Address: 54A Wellhouse Lane Mirfield WF140PW

Application number: 2024/93341	
What is the application for?:	Erection of extension to detached garage block, raising of roof height and erect
Address of the site or building:	54, Wellhouse Lane, Mirfield, WF14 0PW
Postcode:

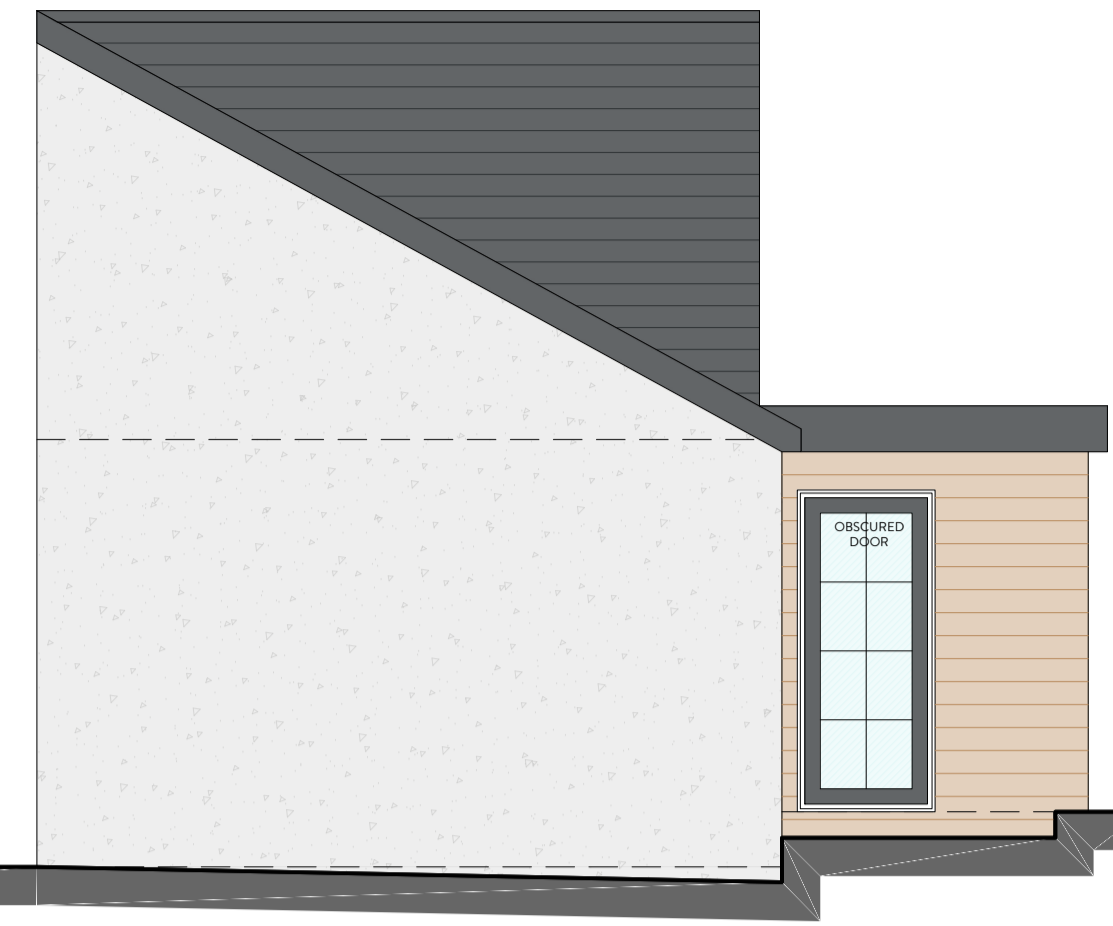
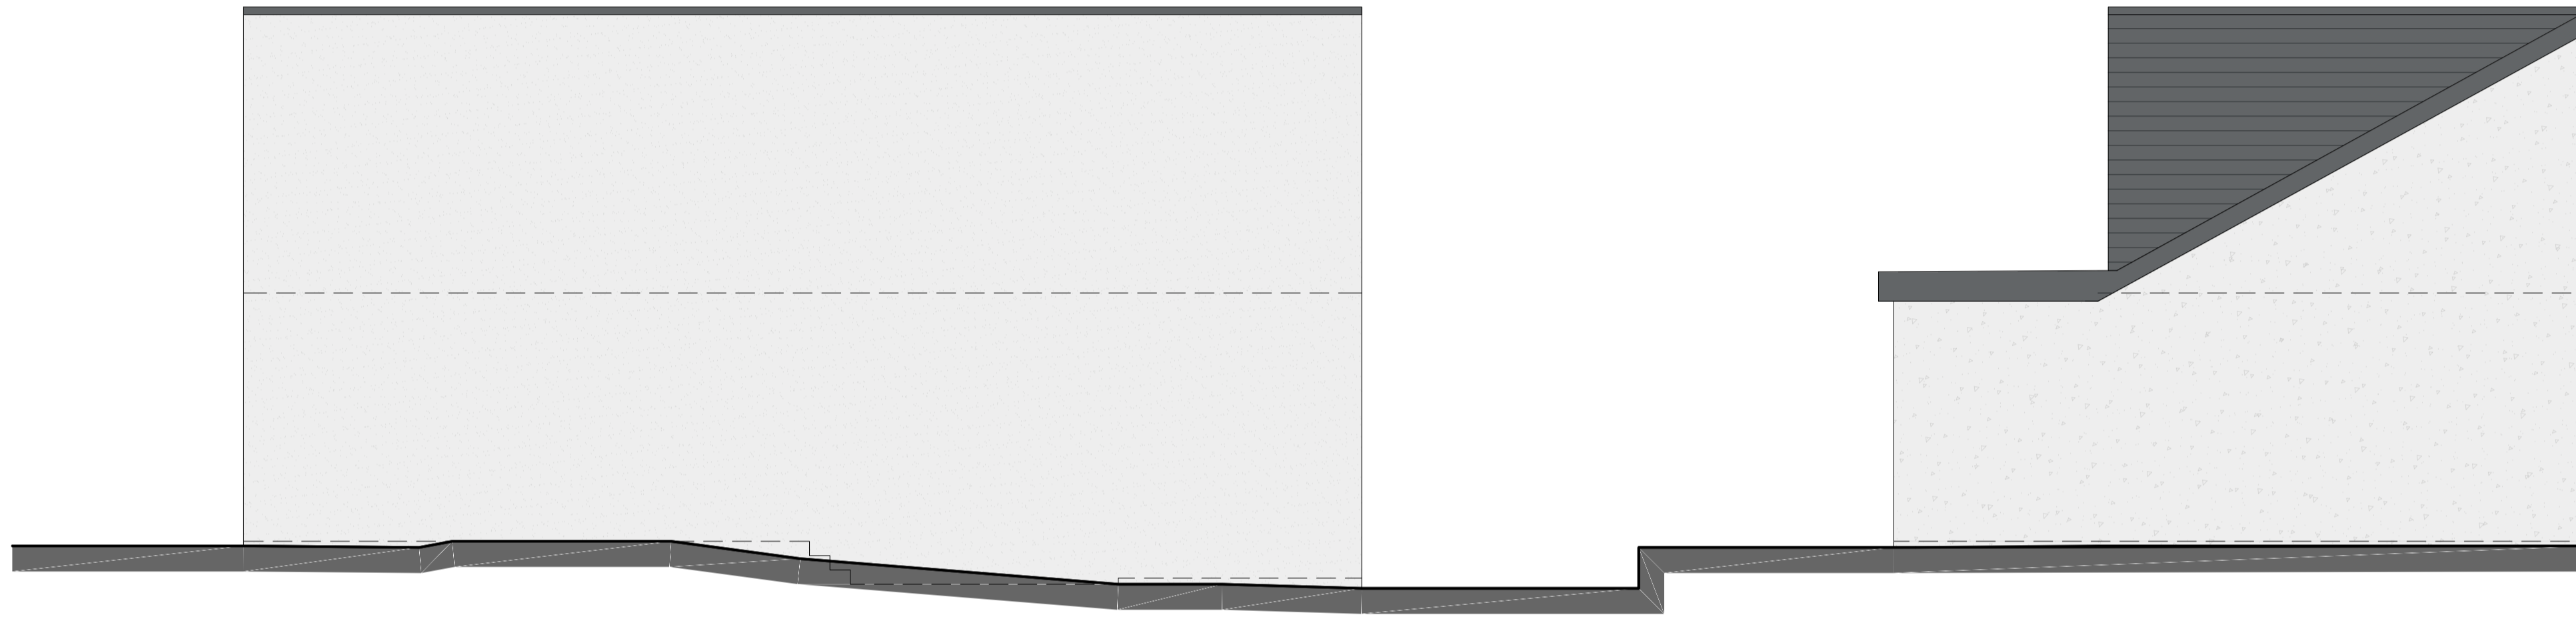
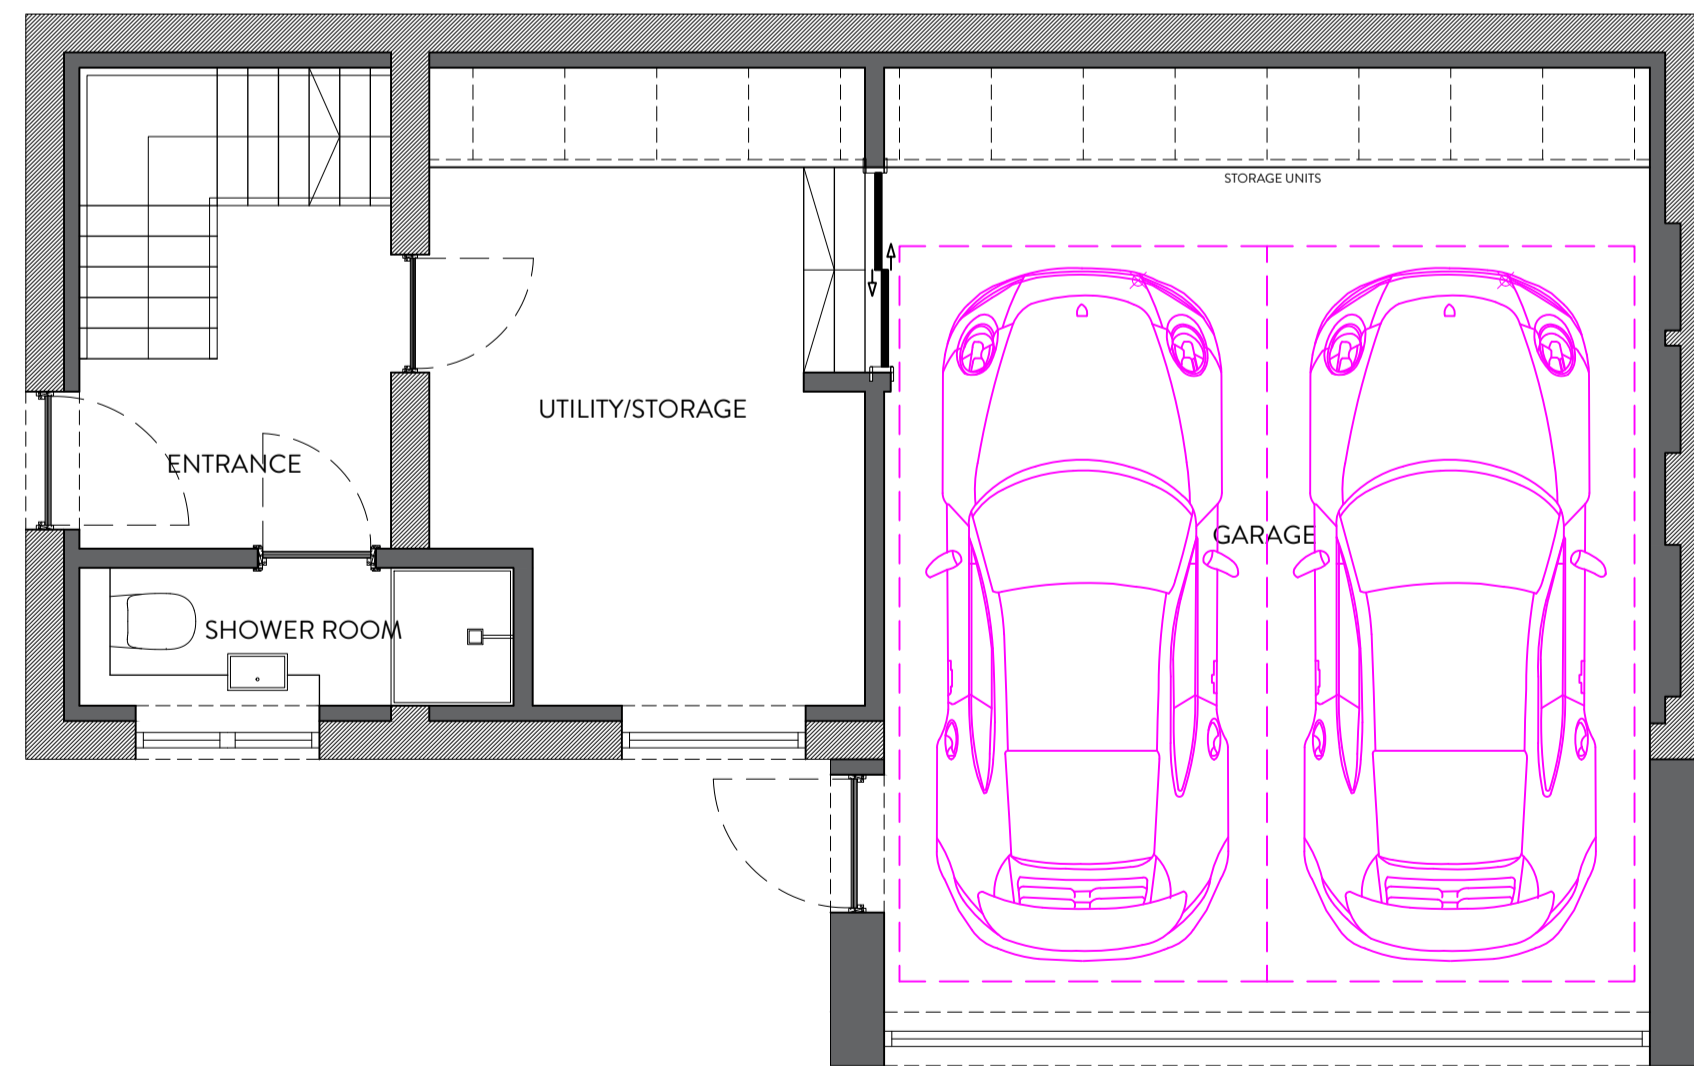
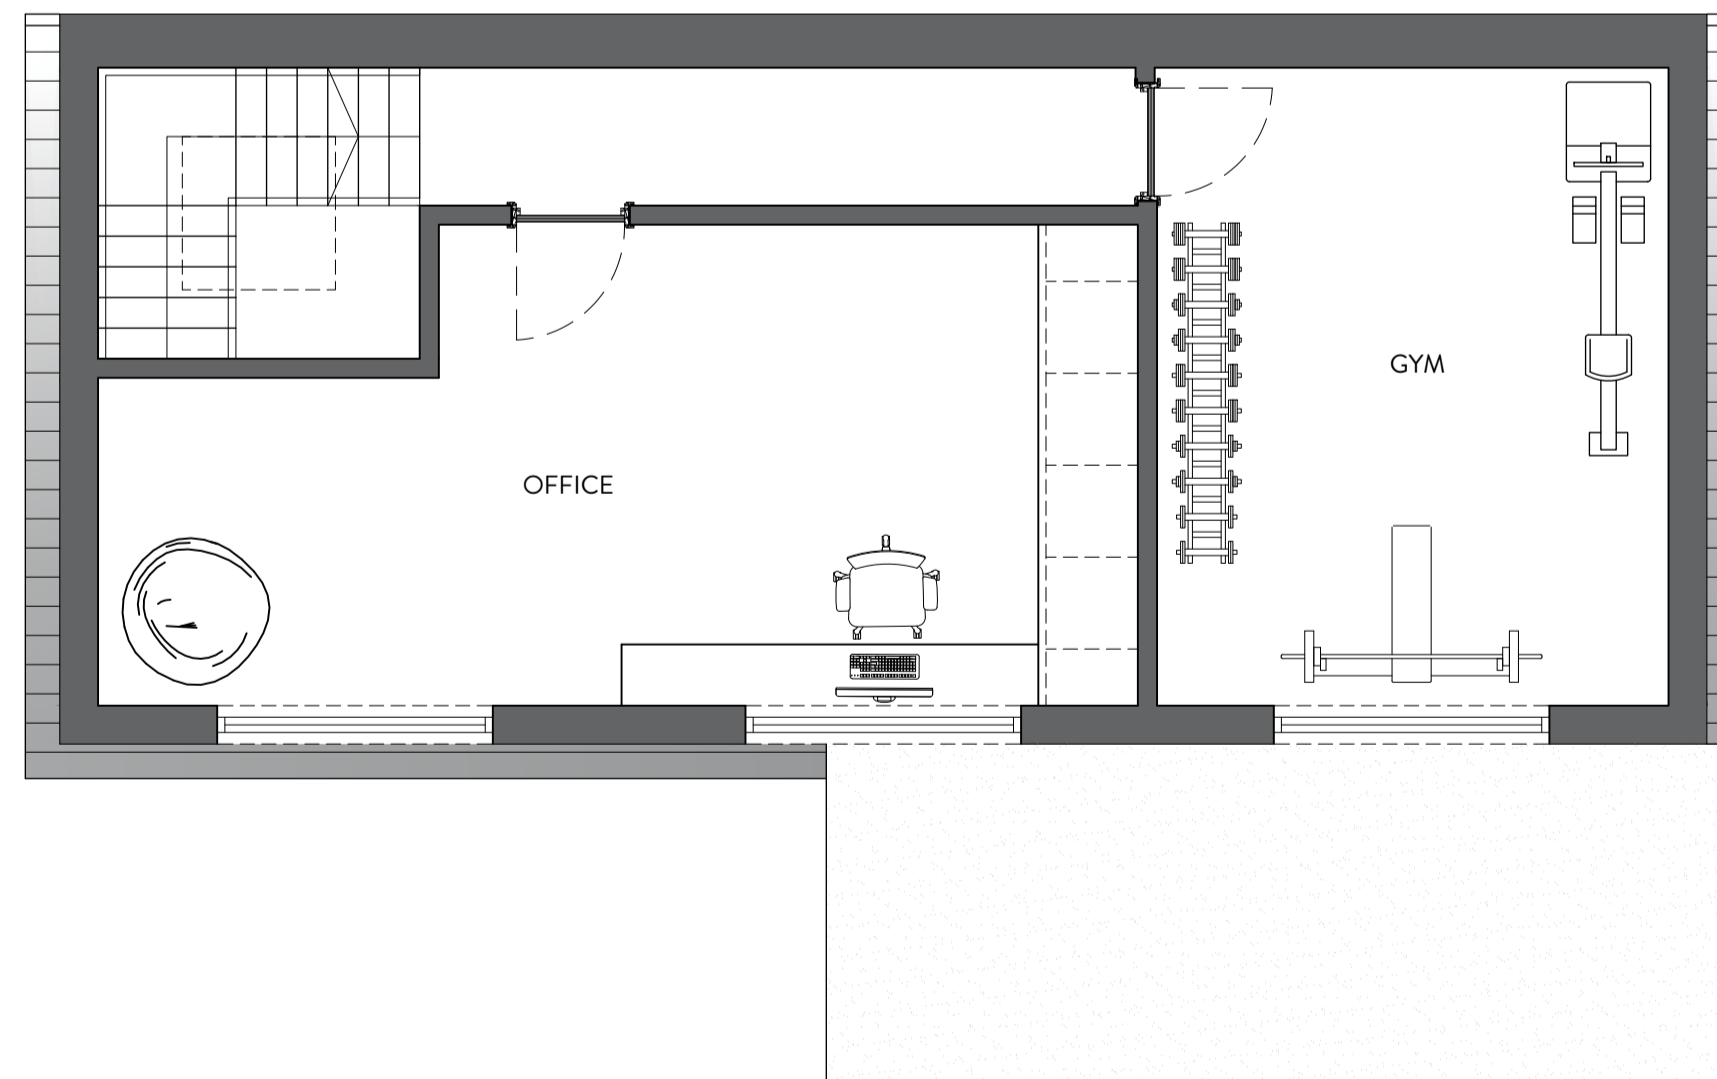
Type of comment: An objection	
Do you wish your comments to be published on the website anonymously?	No
<p>Application to alter the existing garage block number 2024/93341 at 54 Wellhouse Lane, Mirfield WF14 0PW</p> <p>I am writing to object to the application number 2024/93341 with regard to the alterations of the existing stables or garage block being raised in height and making the garage block a two story building with a 1st floor accommodation with dormer windows to accommodate an office and gymnasium.</p> <p>My major concerns is the new height of this addition in the application of the plans submitted, as they do not specify any measurements and with misgivings do not address the over shadowing and light problems this new structure would create to immediate neighbor's at 6 Woodward Court, 54A Wellhouse Lane in the cul-de-sac with 54 Wellhouse Lane on this site and 56A Wellhouse Lane.</p> <p>The access point to the driveway at 54A Wellhouse Lane could become a direct conflict and concern with increased traffic flow and additional parking at 54 Wellhouse Lane.</p> <p>I am also concerned about the Bat population who are regularly active on an evening in this area and it would be advisable to have this issue looked into with regard to avoiding roosting and habitat loss.</p> <p>With these points the proposed planning application should be with reasoning be refused.</p>
